WEST SUSSEX COUNTY COUNCIL CONSULTATION

TO:	Arun District Council FAO: Amber Willard
FROM:	WSCC - Highways Authority
DATE:	29 July 2020
LOCATION:	26 Links Avenue Bognor Regis PO22 7BX
SUBJECT:	FP/81/20/HH Installation of a dropped kerb/crossover. Additional information received.
DATE OF SITE VISIT:	n/a
RECOMMENDATION:	Modification
S106 CONTRIBUTION TOTAL:	n/a

Scale 1:100

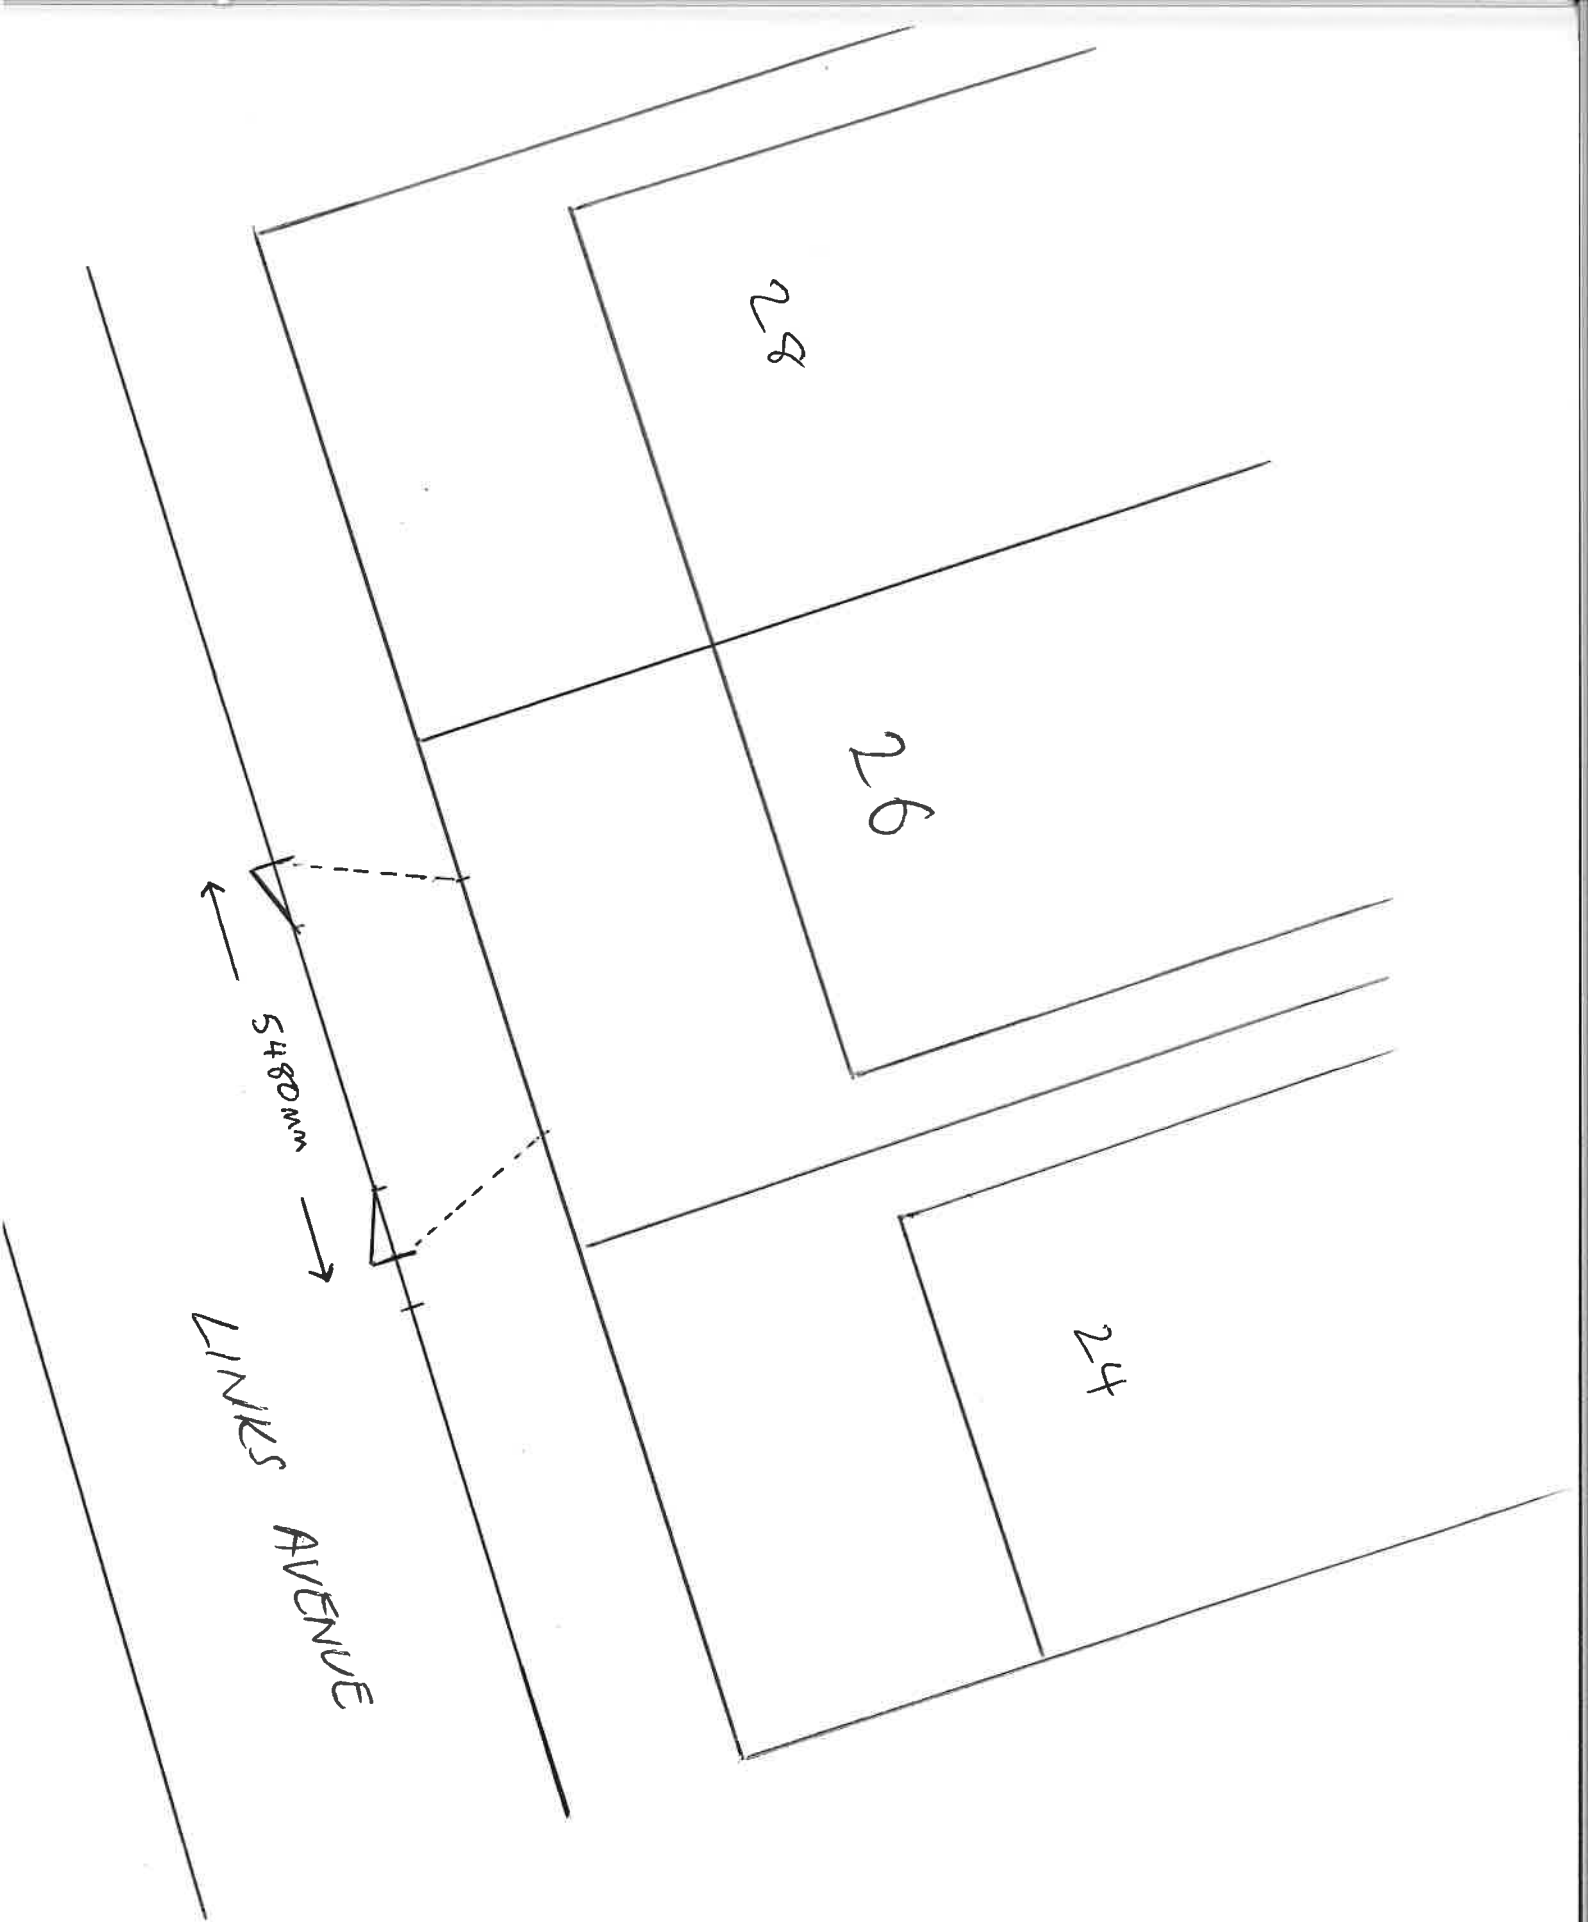
The LHA observes that the new parking area would not be practically accessible due to the location of the Vehicle Crossover (VCO), the LHA therefore advise the applicant modifies the VCO to ensure that a vehicle can access without fouling upon the kerb.

In principle the Local Highways Authority (LHA) does not consider that this proposal would have an unacceptable impact on highway safety or result in 'severe' cumulative impacts on the operation of the highway network. However, the LHA require a modification regarding the VCO position, as described above.
